re: Grading and Site Servicing Plan Review
Proposed Self Storage Development
75 Michael Cowpland Drive – Ottawa, Ontario

date: December 21, 2023

file: PG3798-MEMO.02 Revision 4

SHEET TITLE
GRADING PLAN

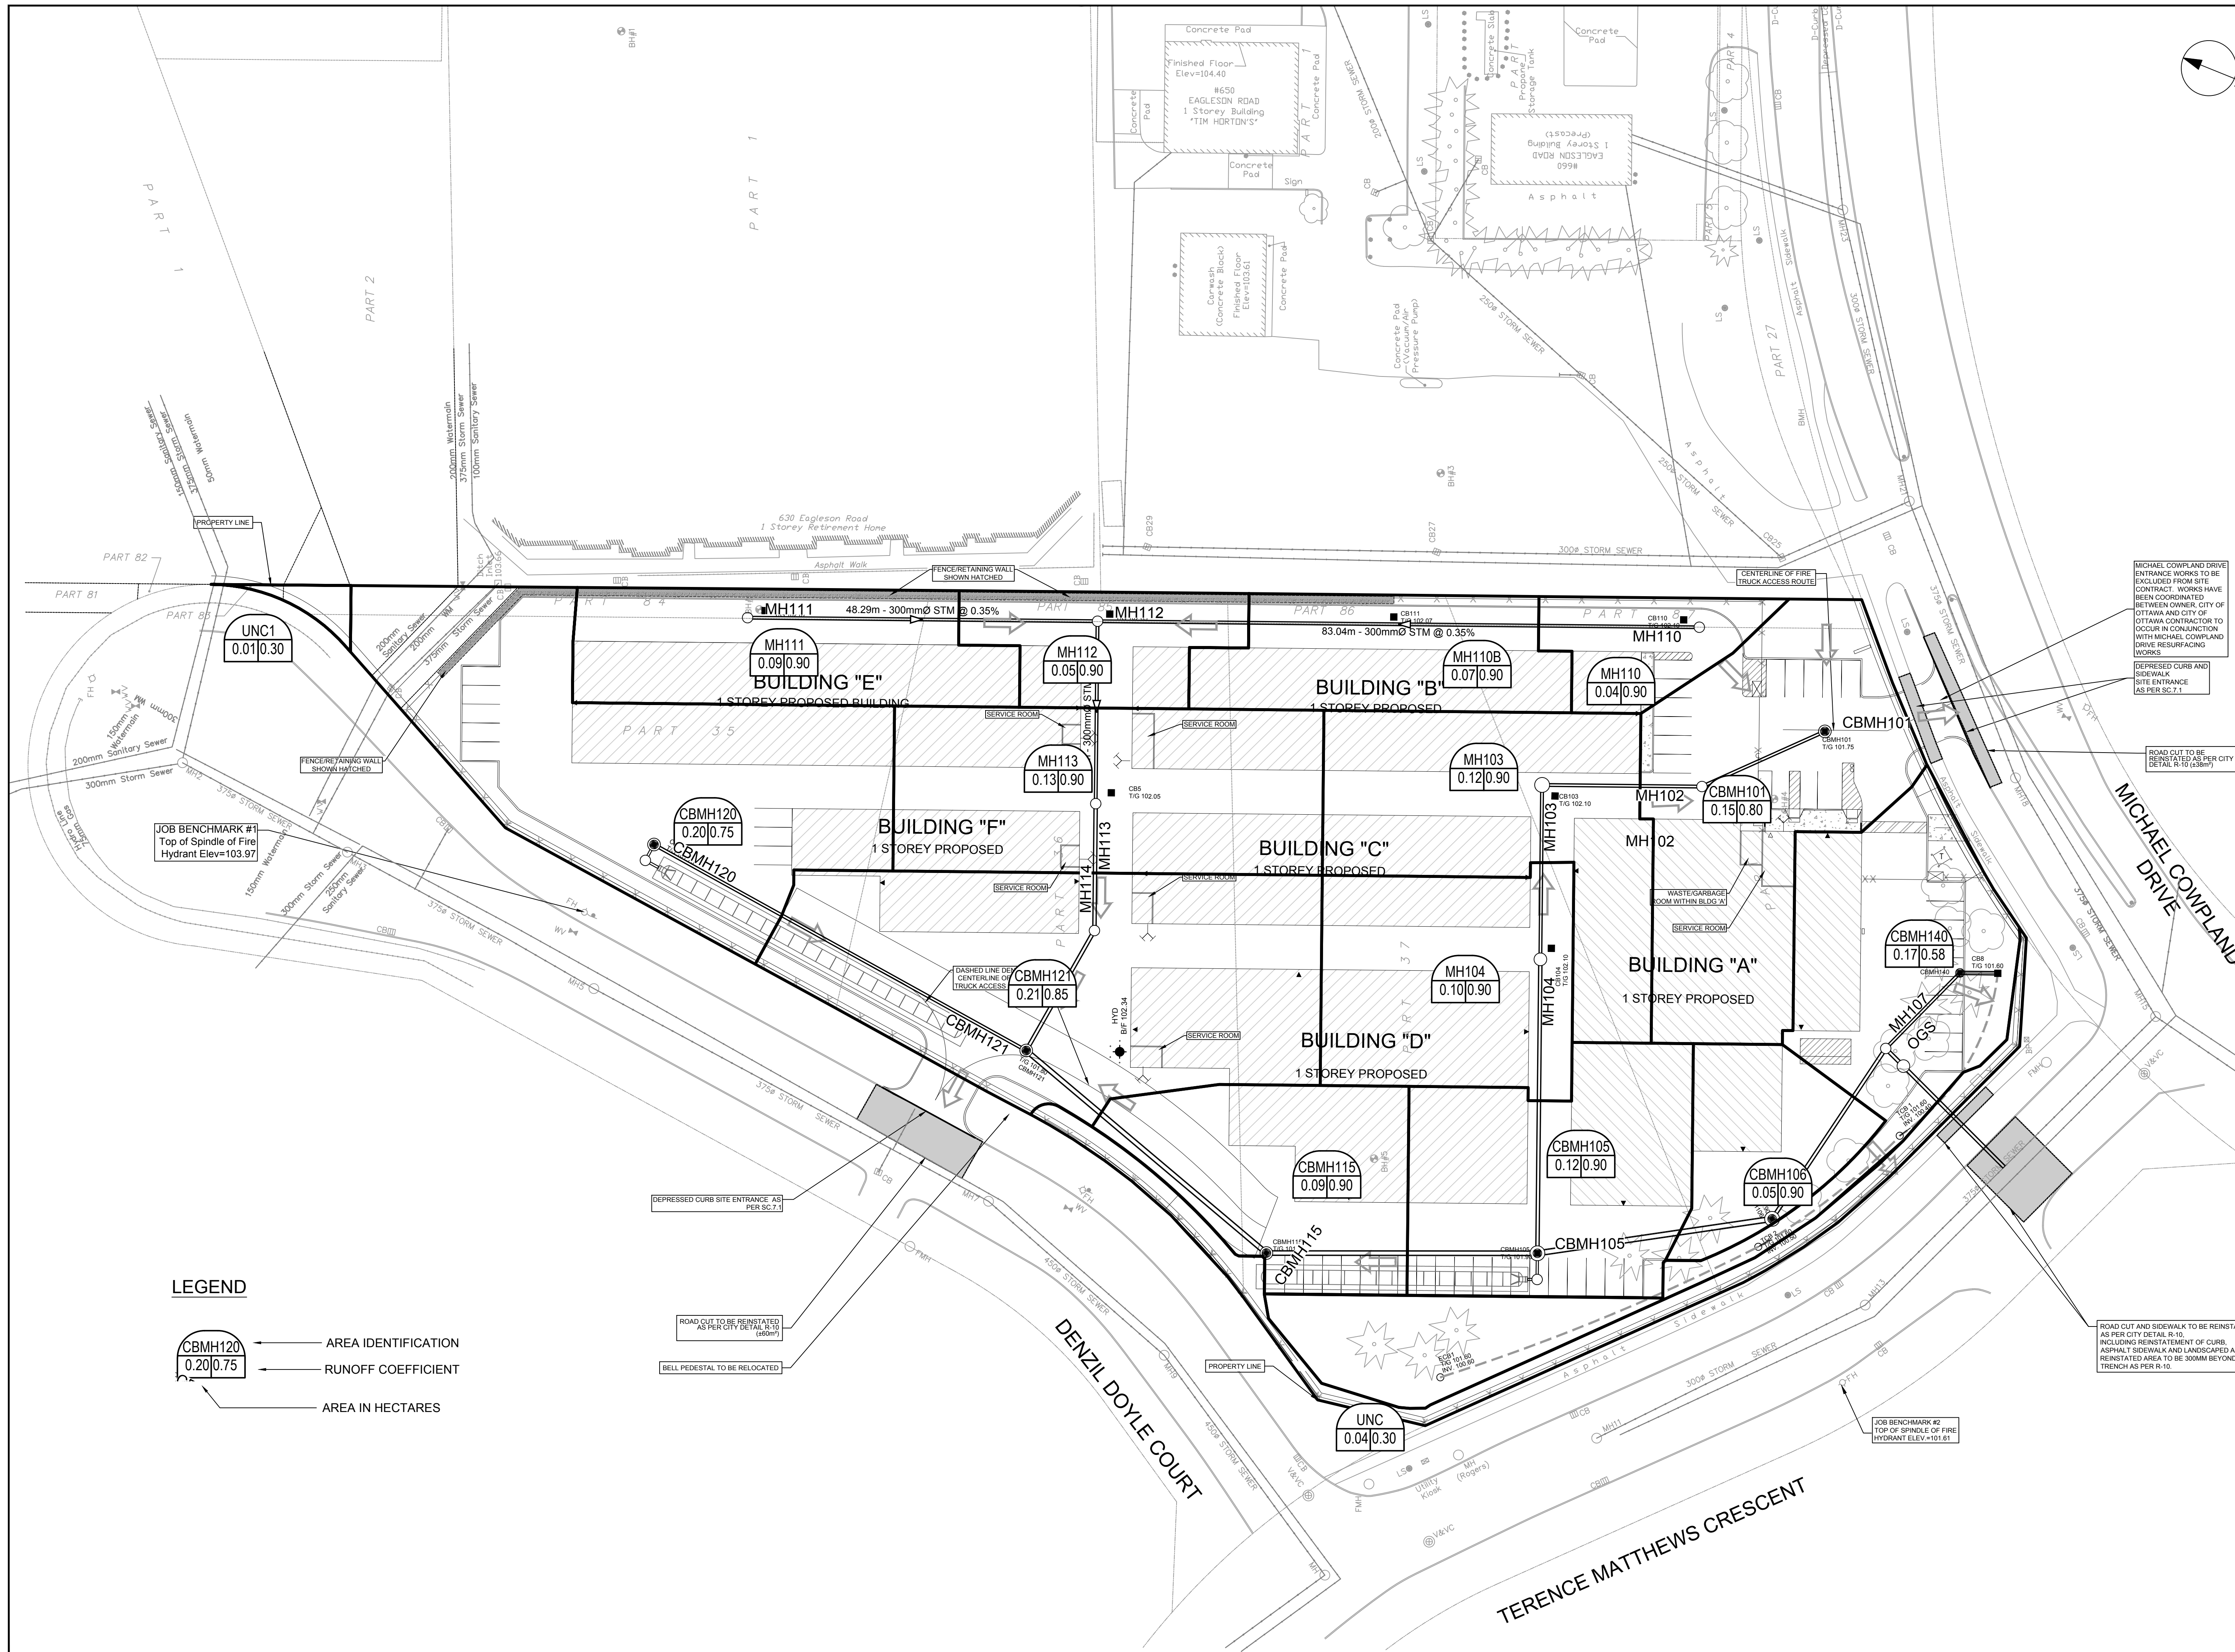
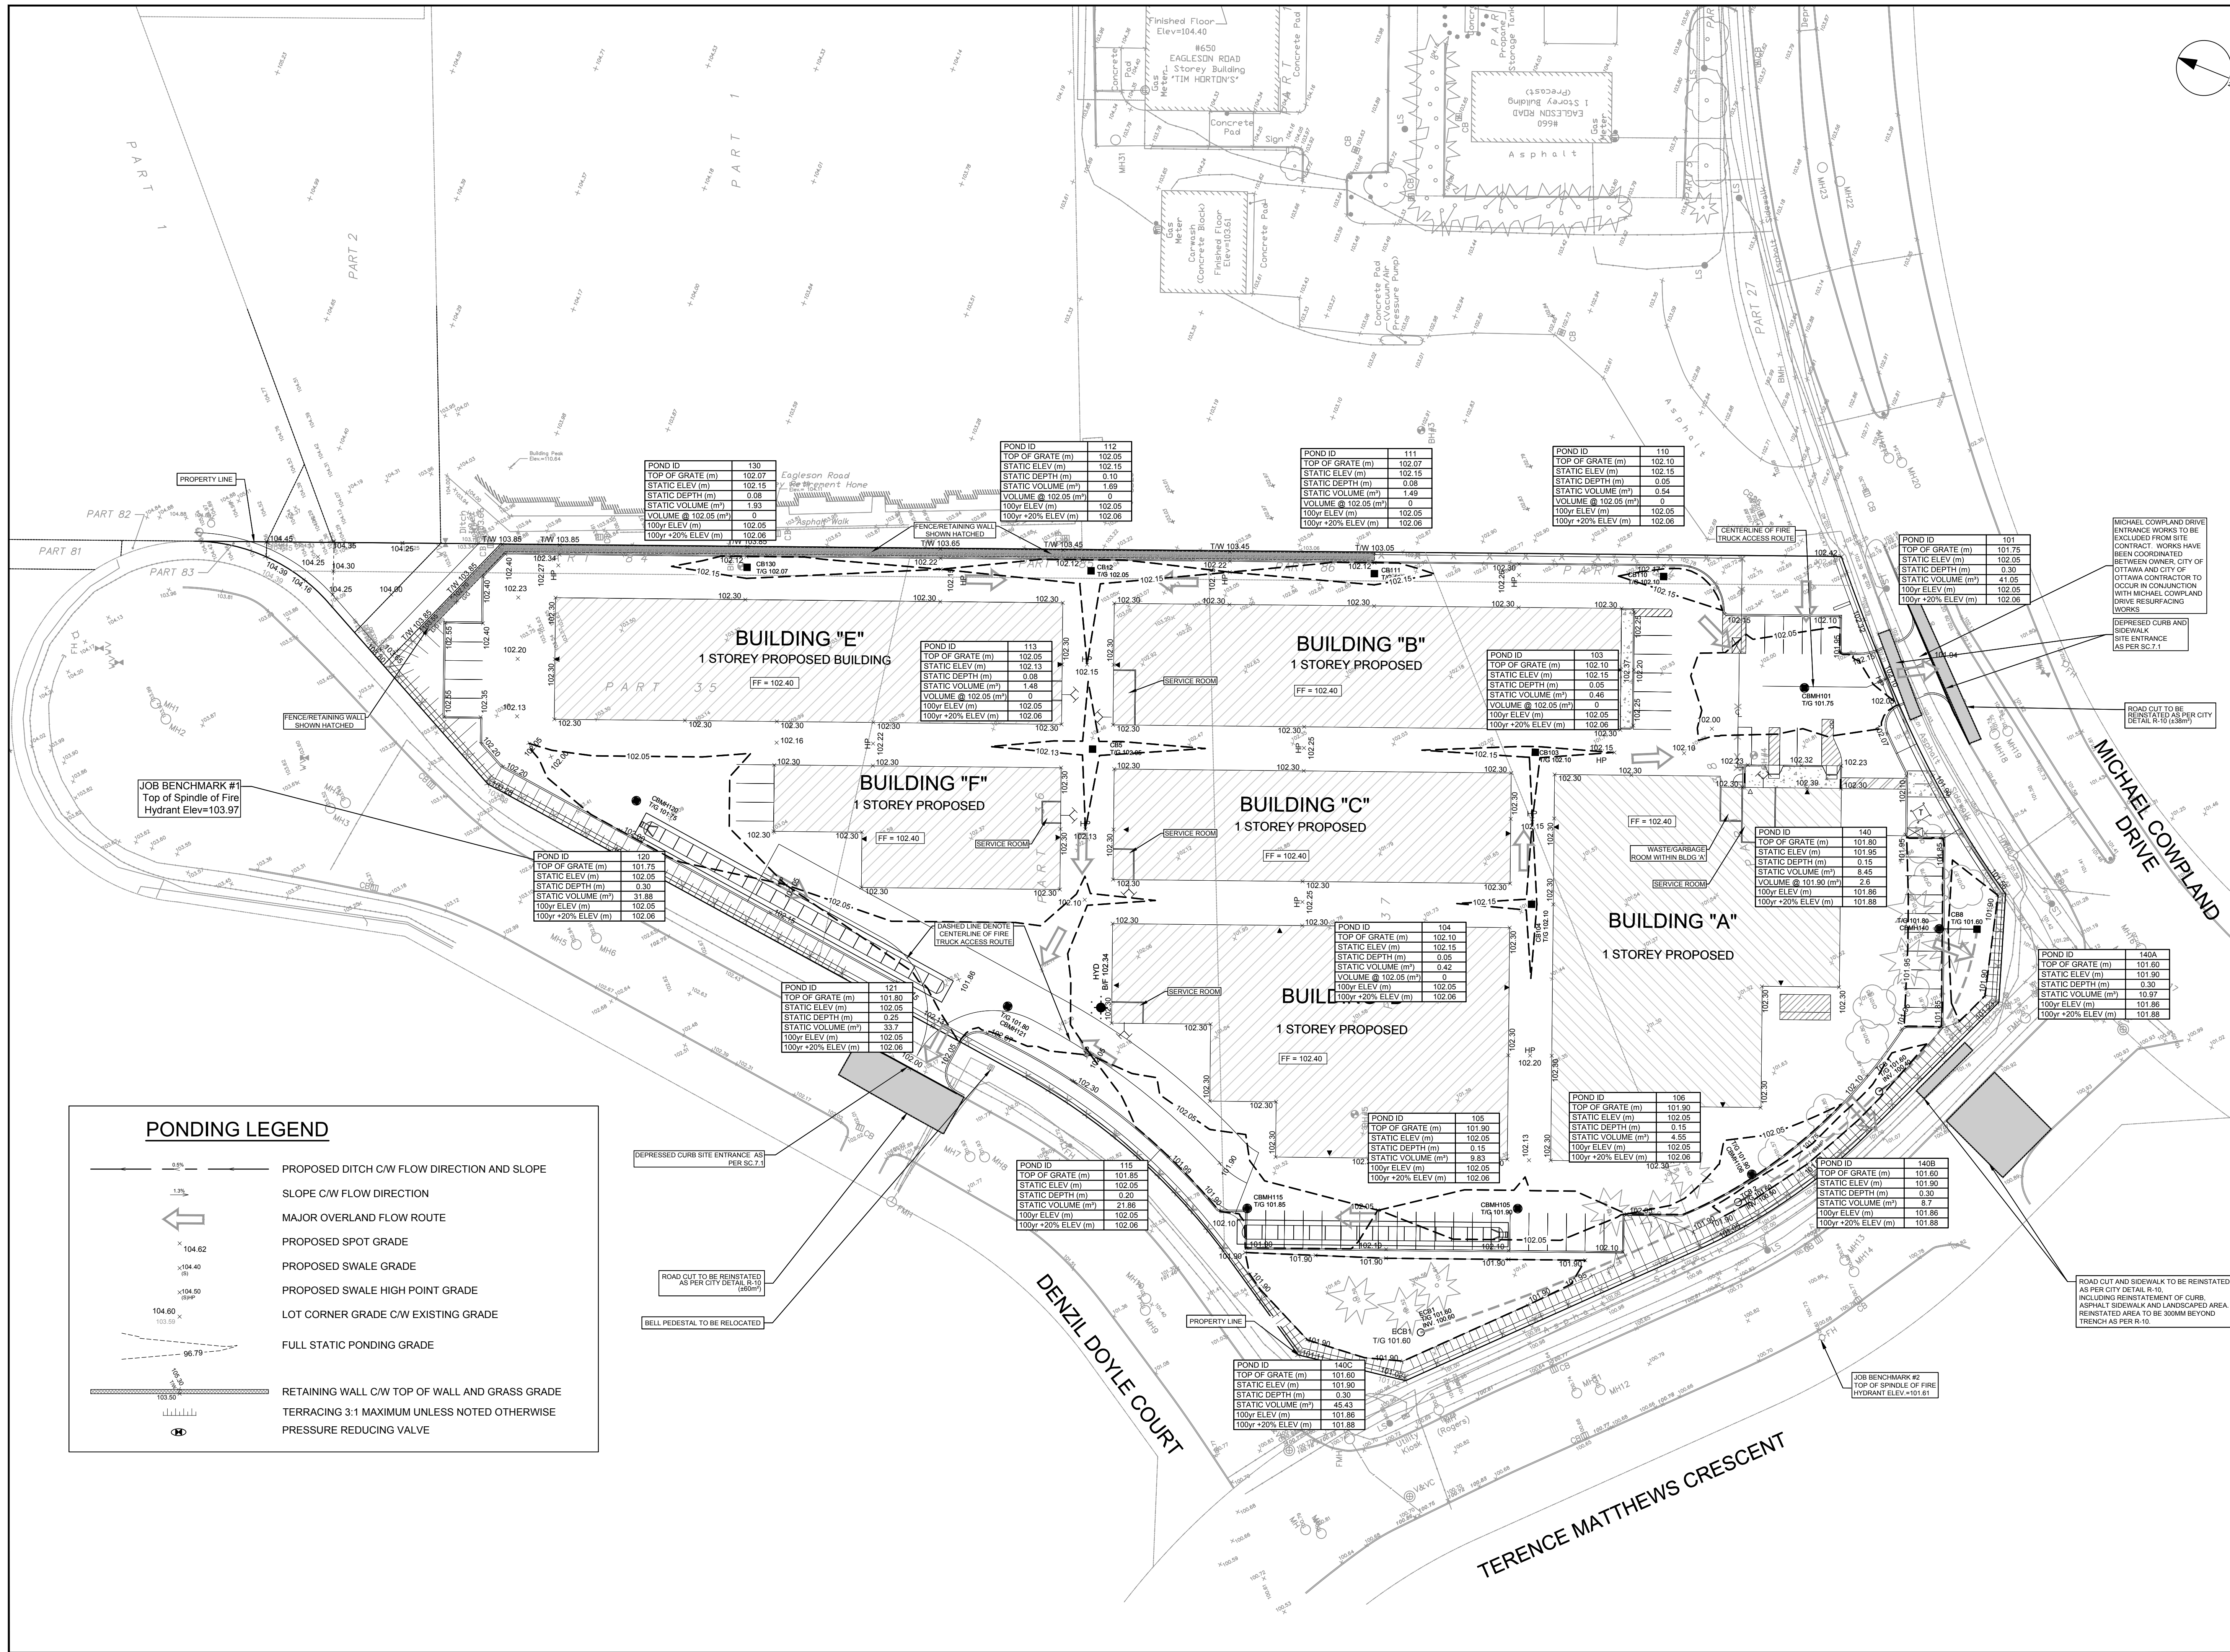
Based on our review of the aforementioned grading plan, the proposed grades around the proposed buildings and throughout the subject site are within the permissible grade raise restriction provided. Based on this, since grade raises are within our recommended grade raise restriction no lightweight fill will be required to accommodate the proposed grading. Therefore, the proposed grading is considered acceptable from a geotechnical perspective.
